DEPARTMENT OF PARKS AND COMMUNITY SERVICES

April 3, 2023

Subject: Homestead at Sterling Ranch Filing No. 3 Final Plat (Vacation and Replat) (VR-23-004)

# HOMESTEAD AT STERLING RANCH FILING NO. 3

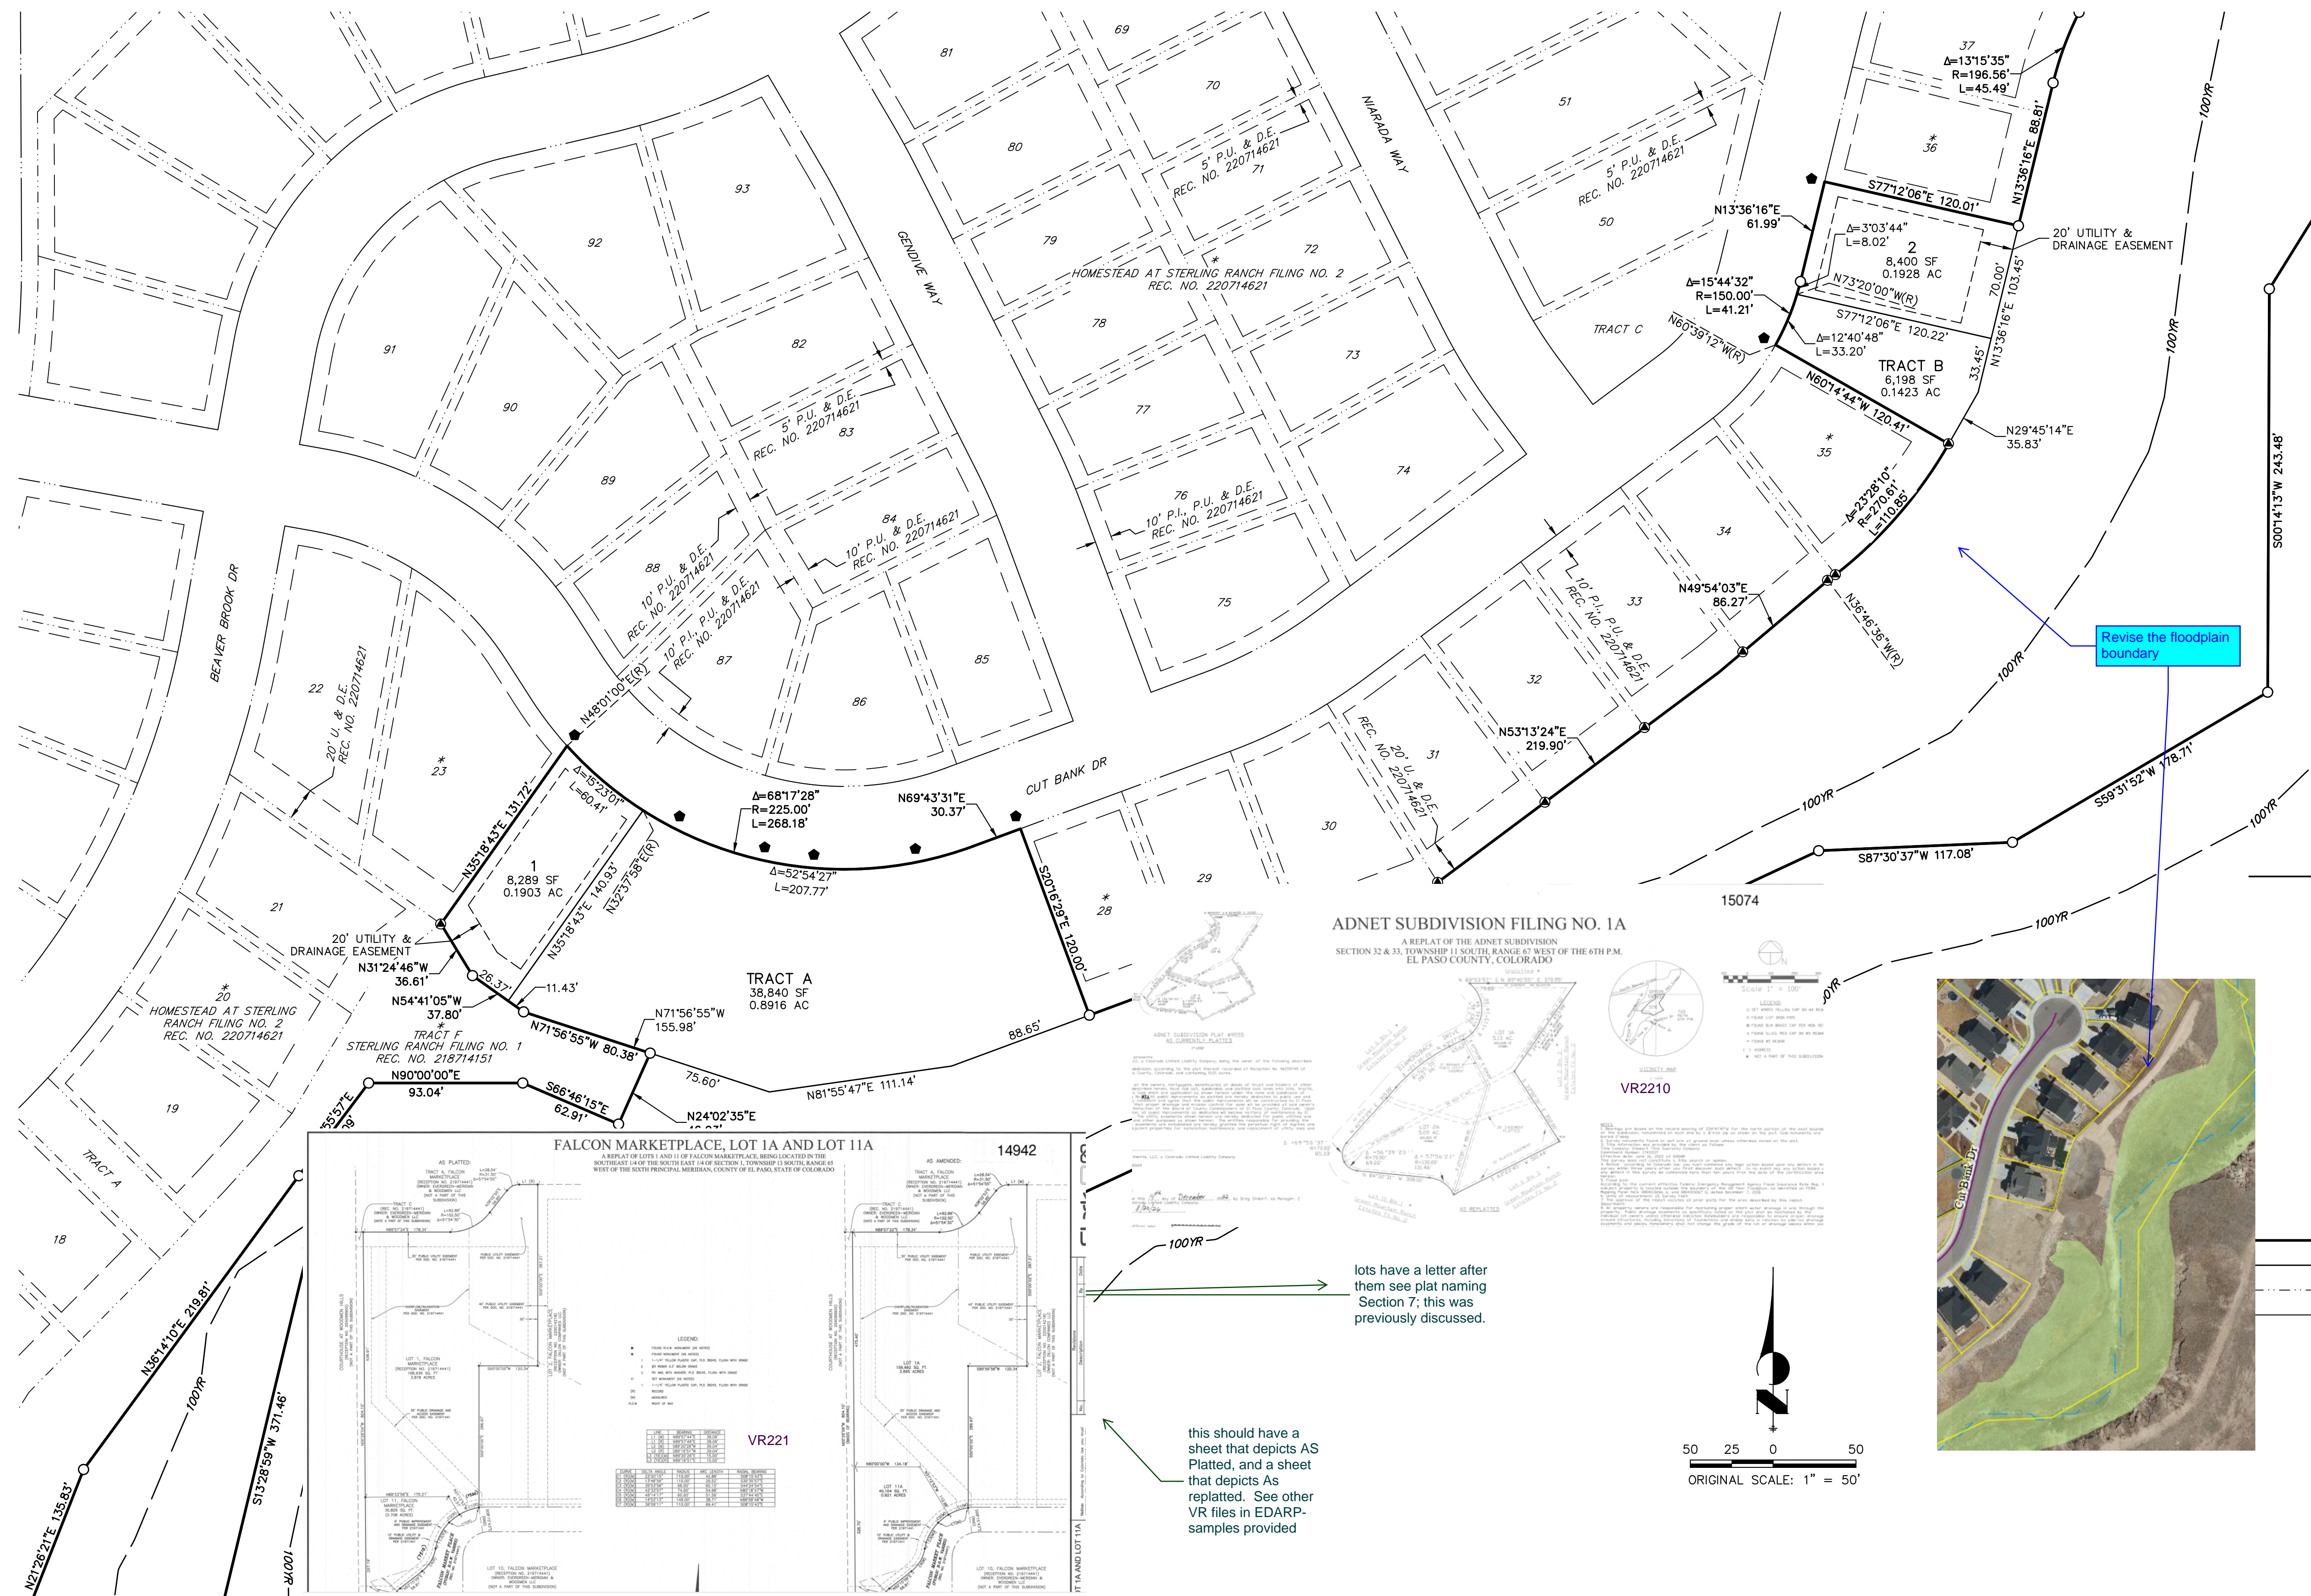
The 2022 El Paso County Parks Master Plan shows the project directly impacting the Sand Creek Primary Regional Trail. This trail corridor is located along the western banks of the Sand Creek channel and has been acknowledged previously in Sterling Ranch Master Plat Filing No. 1, Homestead at Sterling Ranch Filing No. 2 Final Plat, Branding Iron at Sterling Ranch Filing No. 2, and the Sand Creek Channel Construction Documents. However, the current submitted Final Plat and Letter of Intent do not mention the Sand Creek Regional Trail nor the easements dedicated to the construction, maintenance, and public access of the trail itself.

The El Paso County Planning Commission and Board of County Commissioner summaries for the approval of the Sterling Ranch Phase I Preliminary Plan added a requirement for the dedication to El Paso County of a 25-foot-wide regional trail easement along Sand Creek, within Tract D, for the construction, maintenance, and public access of the Sand Creek Primary Regional Trail. This trail easement, Instrument #218054786, was dedicated to the Sterling Ranch Metropolitan District in May 2018 and is currently located wholly within Tract C of Homestead at Sterling Ranch Filing No. 3. This easement, as previously noted, is not shown in the Final Plat drawings nor notated in the Plat Notes.

El Paso County Parks staff highly recommends the inclusion of the Sand Creek Regional Trail easement in the Homestead at Sterling Ranch Filing No. 3 Final Plat drawings and Plat Notes section. Furthermore, staff requires the final dedication of the previously dedicated Sand Creek Regional Trail easement from the Sterling Ranch Metropolitan District to El Paso County prior to the recording of this Final Plat.

Recommend to the Planning Commission and Board of County Commissioners that approval of the Homestead at Sterling Ranch Filing No. 3 Final Plat (Vacation and Replat) include the following conditions: (1) show in the Final Plat drawings and notate in the Plat Notes the previously designated 25-foot trail easement along the west side of Sand Creek within Tract C that allows for public access, construction, and maintenance by El Paso County of the Sand Creek Primary Regional Trail; (2) dedicate to El Paso County from Sterling Ranch Metropolitan District the previously-dedicated 25-foot trail easement along the Sand Creek corridor, recorded as Instrument #218054786, prior to the recording of this Final Plat; (3) fees in lieu of land dedication for urban park purposes are not required pursuant to the existing Urban Park Lands Agreement (BoCC Resolution 20-50) and Park Lands Agreement Extension (BoCC Resolution #22-325) and are subject to provision of neighborhood park amenities at Homestead Park.
